25 September 2014

Reference: Grafton Bridge
Contact: David Morrison

Comments on EIS - Second Crossing of the Clarence River at Grafton
Your Ref : SSI - 6103

Figure 2.6: Grafton levee system

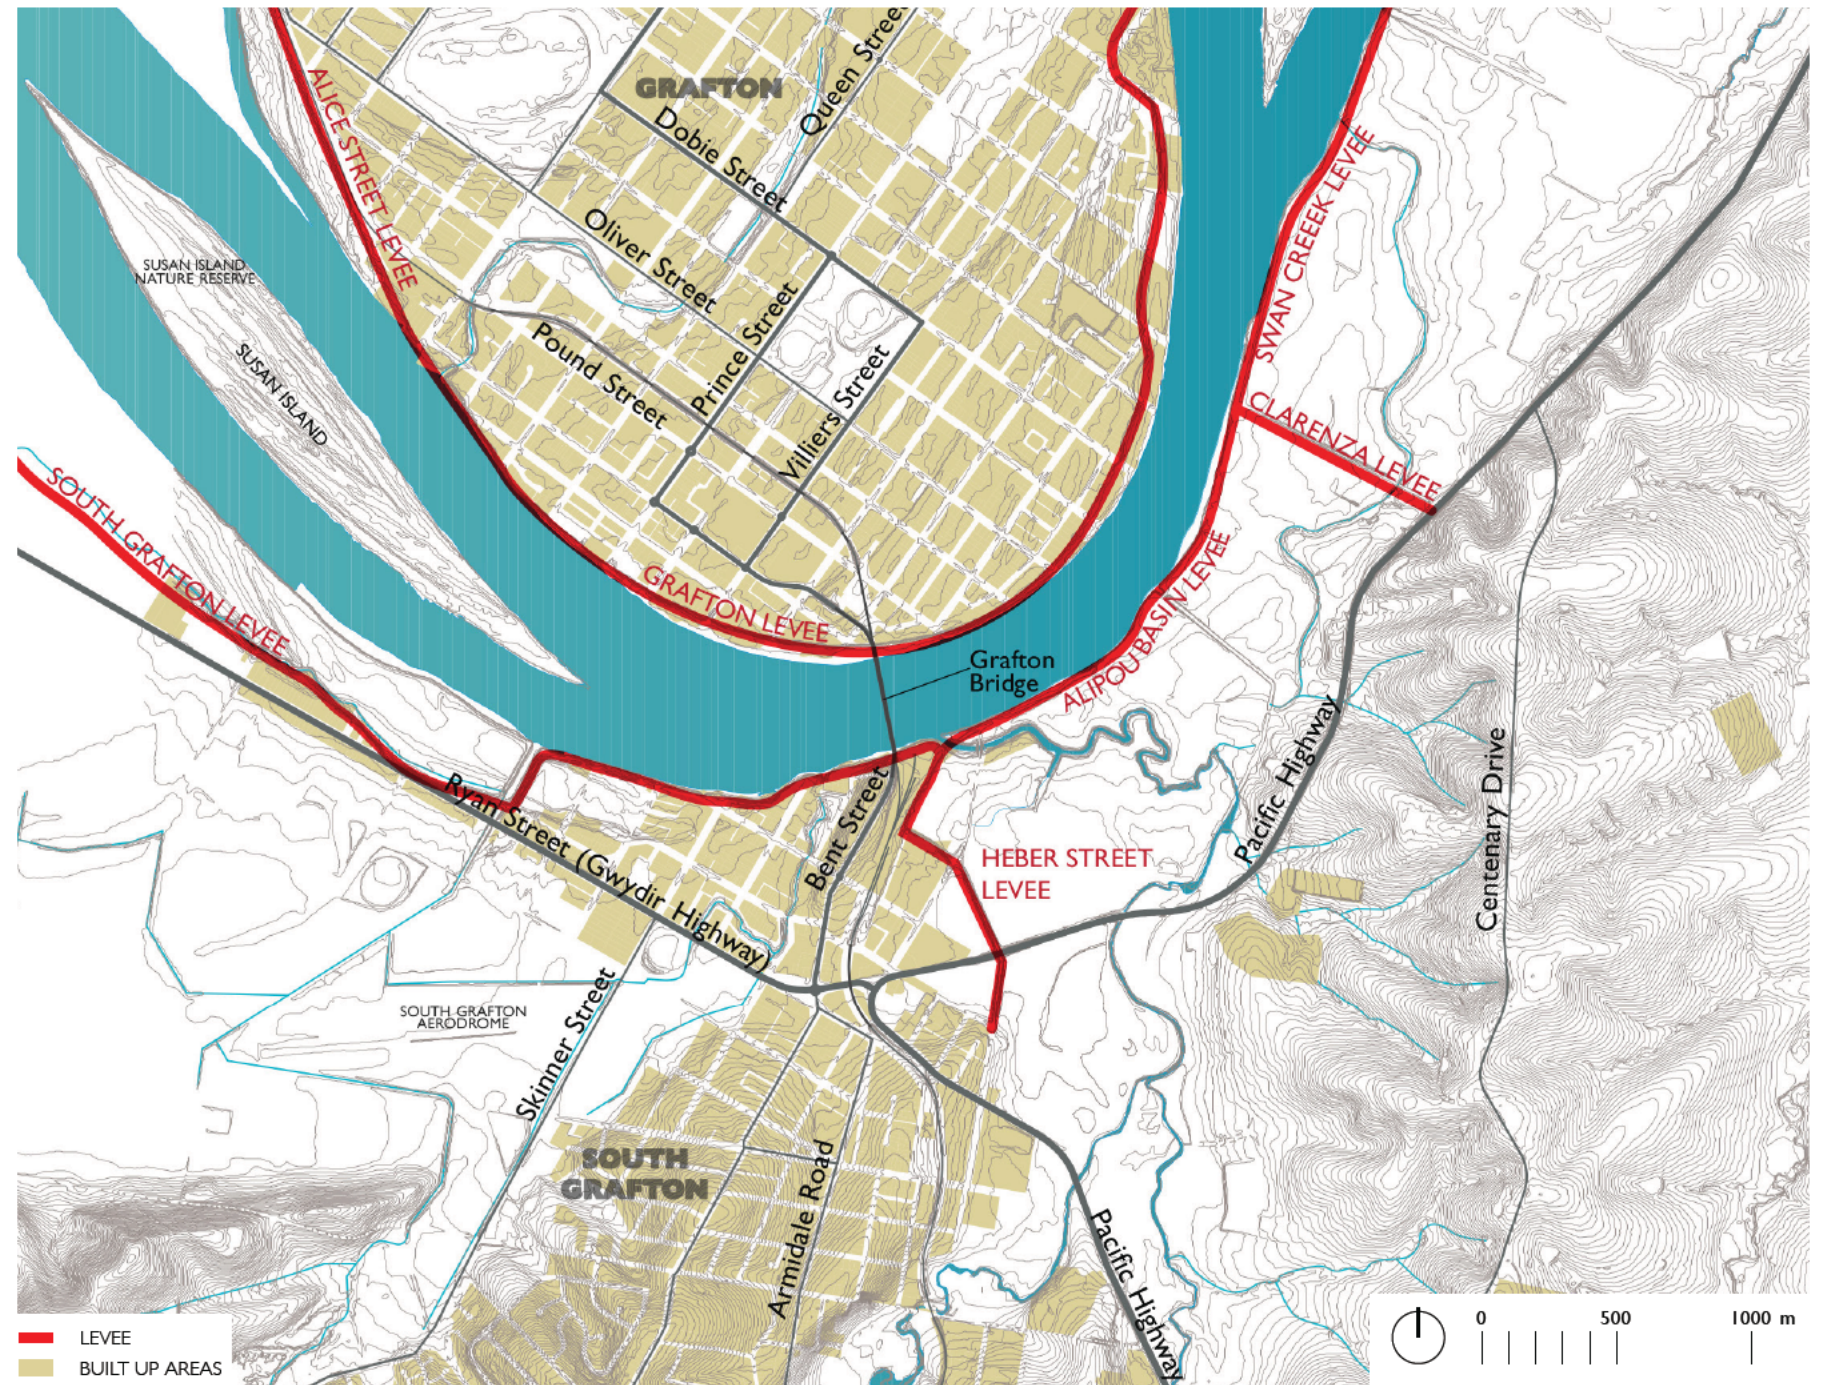
- The EIS identifies raising of the levee by up to 200mm, but it is not clear whether this is a uniform raising of the whole levee or a maximum raising at identified low points

- The EIS has not addressed the practicality or feasibility of raising the levee given that there are a number of logistical constraints such as buildings. Therefore it has not been demonstrated that raising of the levee to ameliorate afflux impacts from the bridge is able to be implemented.
